Application for a non-material amendment following a grant of planning permission.

Change of use of premises from Class B8 to B1c/B2/B8, including internal and external alterations, demolition of ancillary structures and new access to Southam Road

Reference number:	<input type="text" value="18/01246/F"/>
Date of decision	<input type="text" value="20/12/2018"/>

Alterations to office cladding configuration and colour.  
Level of cladding to base of front elevation revised.  
Additional window added.  
Access gate location amended.  
Barrier island revised

Banbury 200 Unit,
 Southam Road, Banbury
 Proposed Site Plan

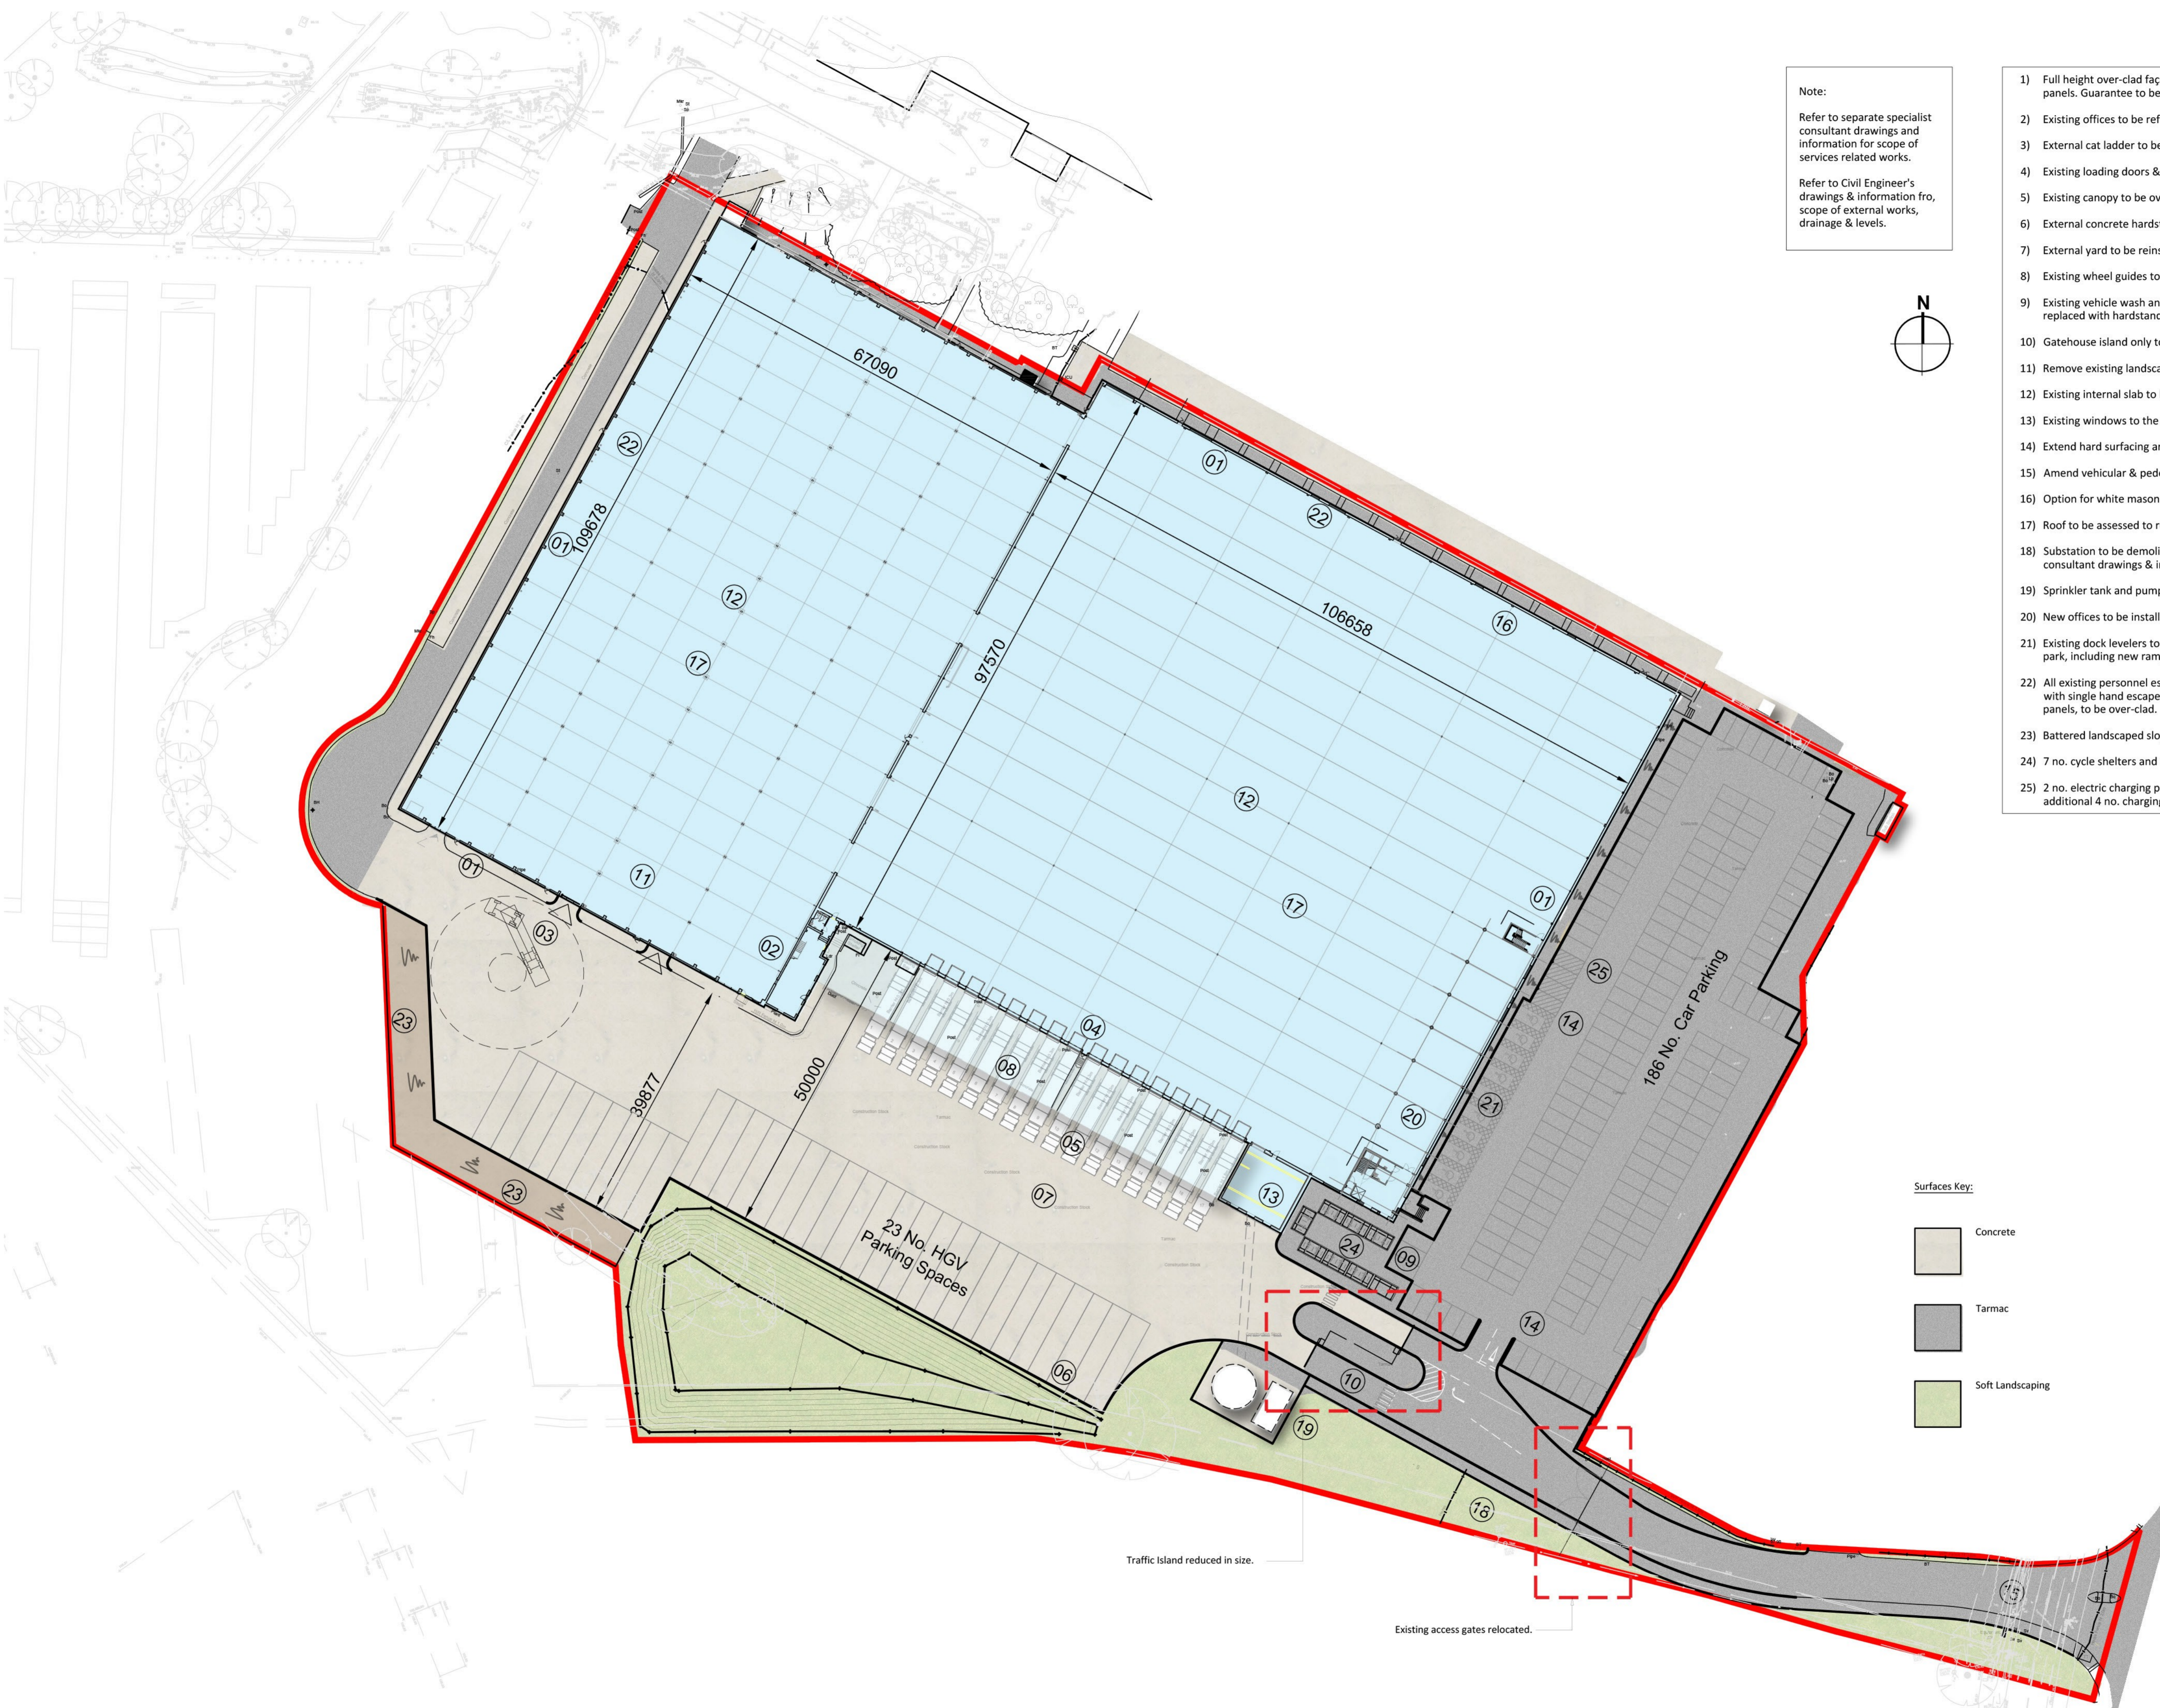
Alterations to office cladding configuration and colour - potential end user preference.  
Level of cladding to base of front elevation revised - existing site levels and existing footing don't allow for original proposal  
Additional window added - existing window opening not overclad.  
Access gate location amended - existing gates relocated to suit revised road width.  
Barrier island revised - initial proposal clashes with existing drainage.
